Application No: BE/143/21/HH
Site Address: 19 South Way Bersted PO21 5HB
Description of works: Removal of existing three lean-to structures and erection of single storey side and rear extension.

Thank you for your internet representation made on 2nd December 2021 which has been recorded as an objection with the comments as follows:

sheet 1 b of 3

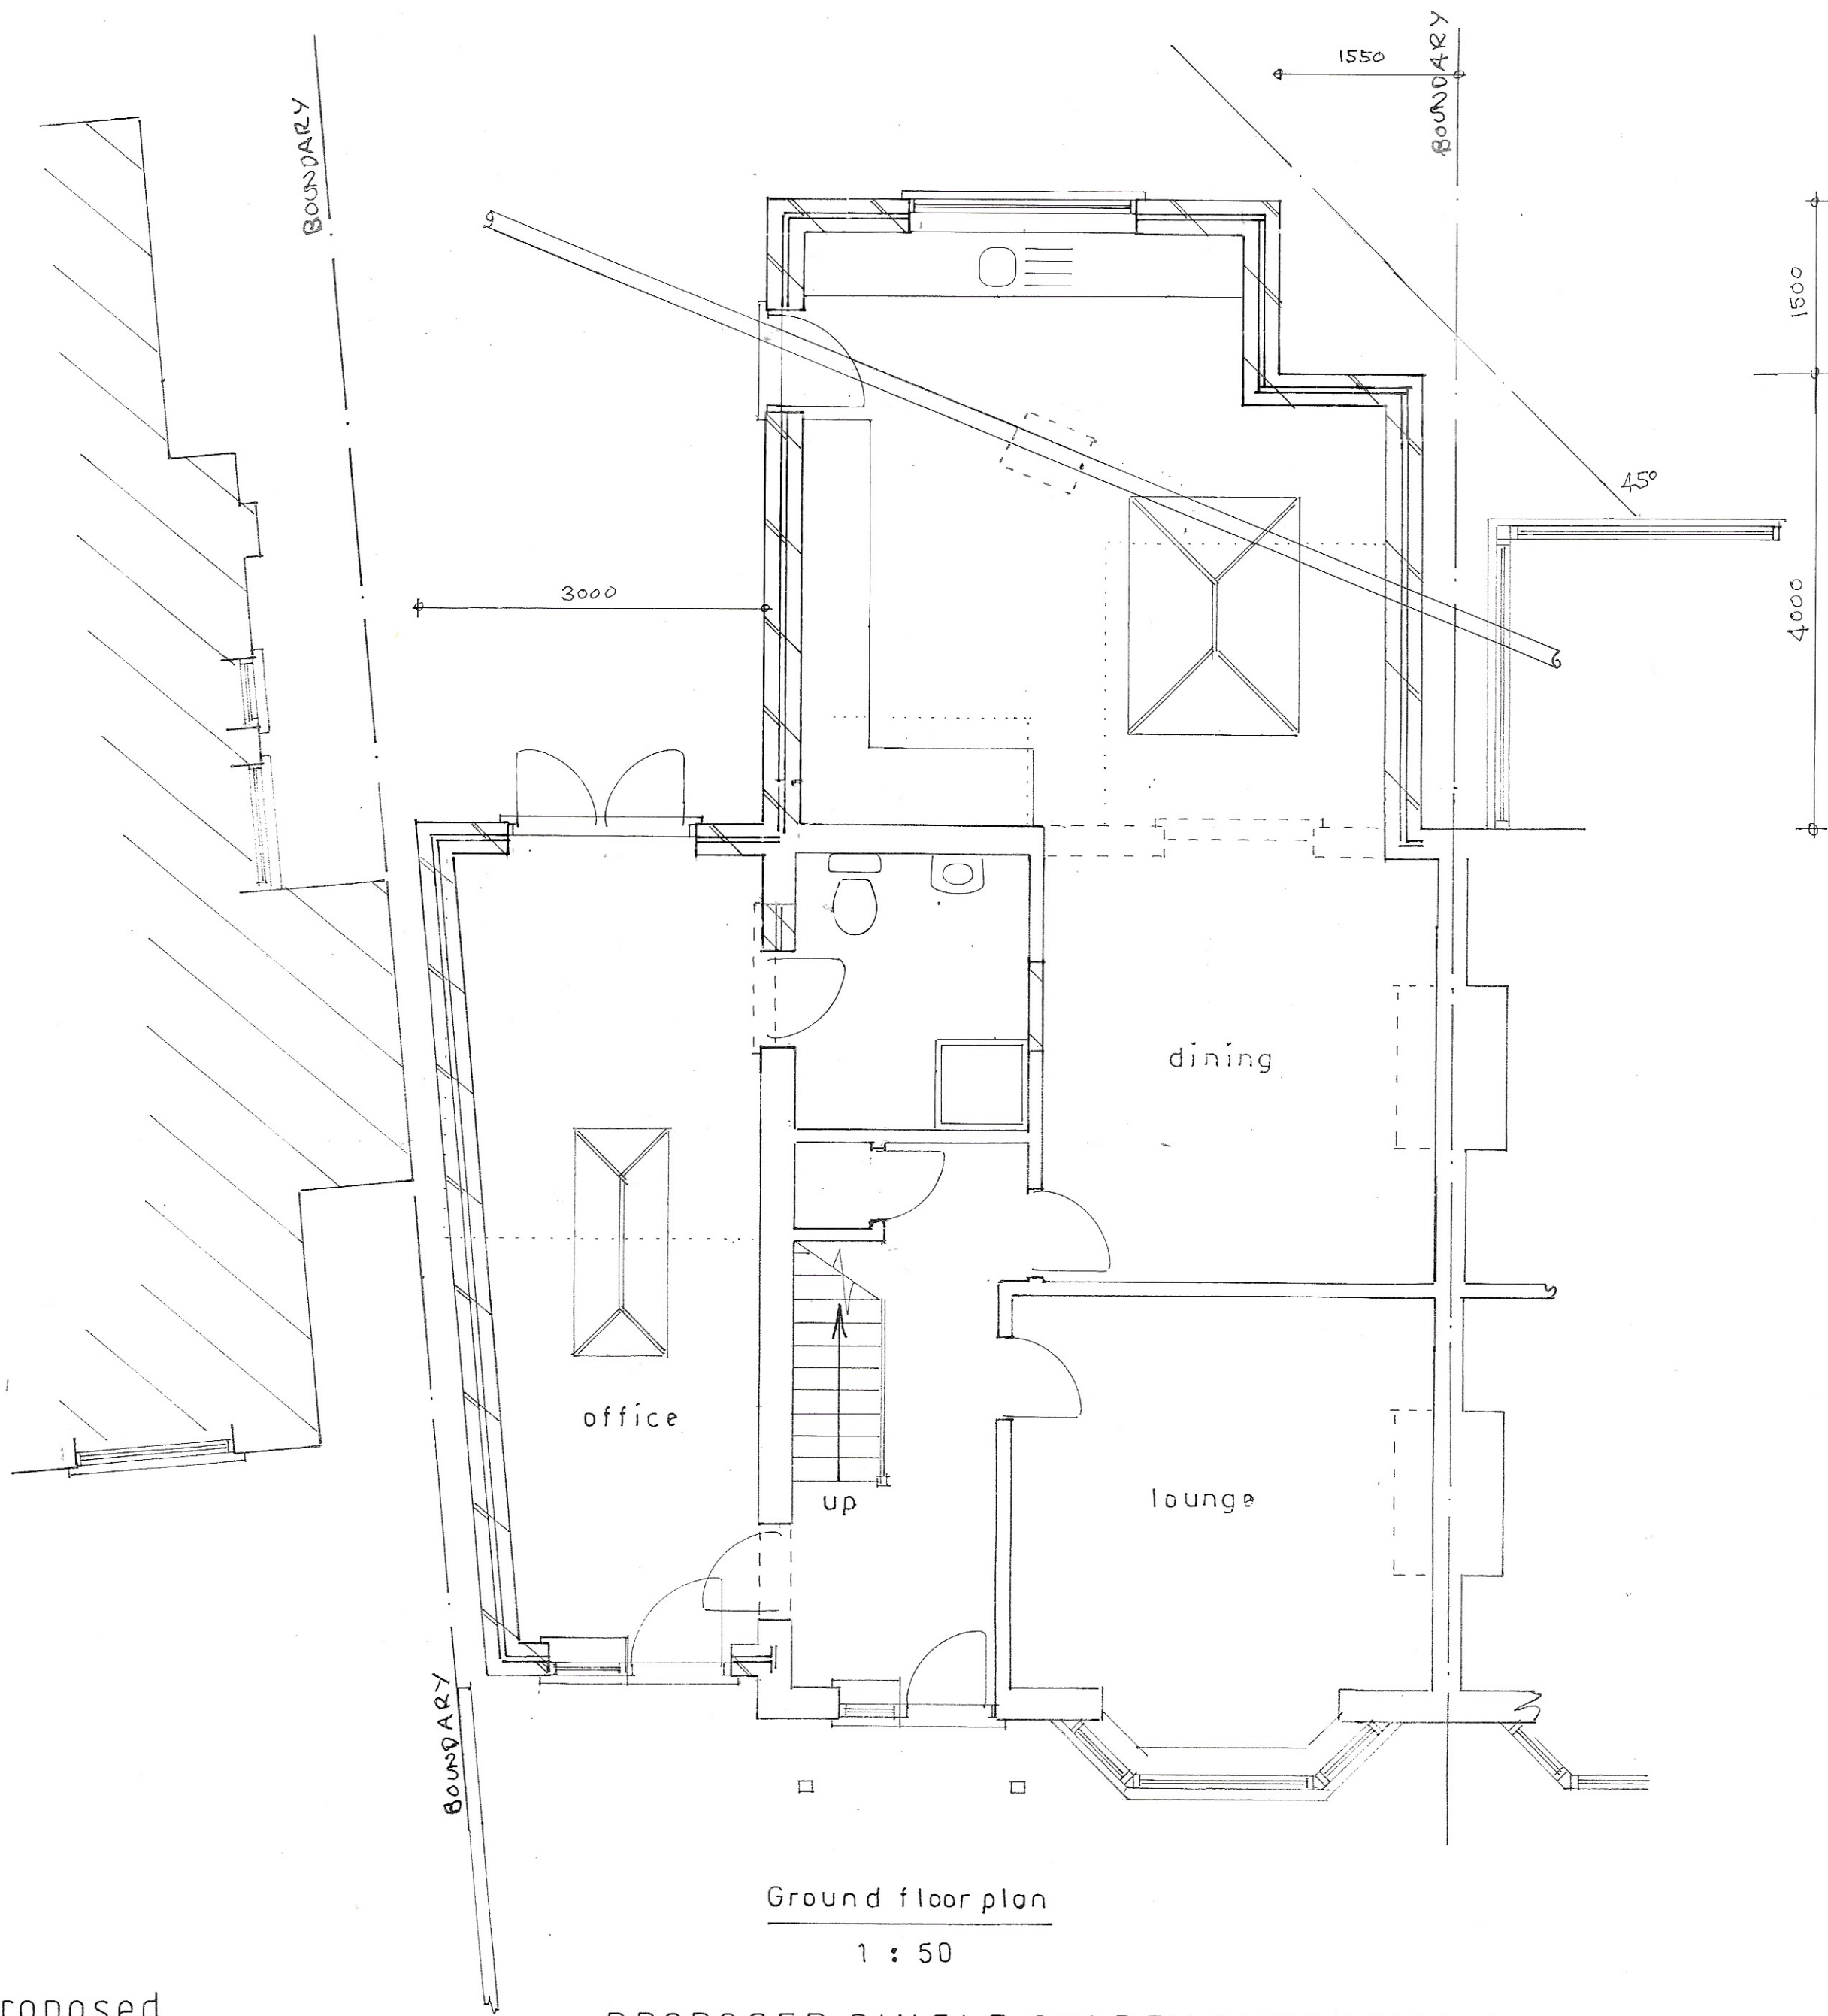
Even with the revised plans I don't understand why the need for an toilet/shower room is needed within an office, this would still lead to be used as another bedroom.

Within the plans it shows they are wanting to build over the main drains which feeds at least 6 properties from the street, which raises my concerns on the public services (drains) as they are already just over 90 years old, as well as the extra strain from the toilets/washing factices they are adding.
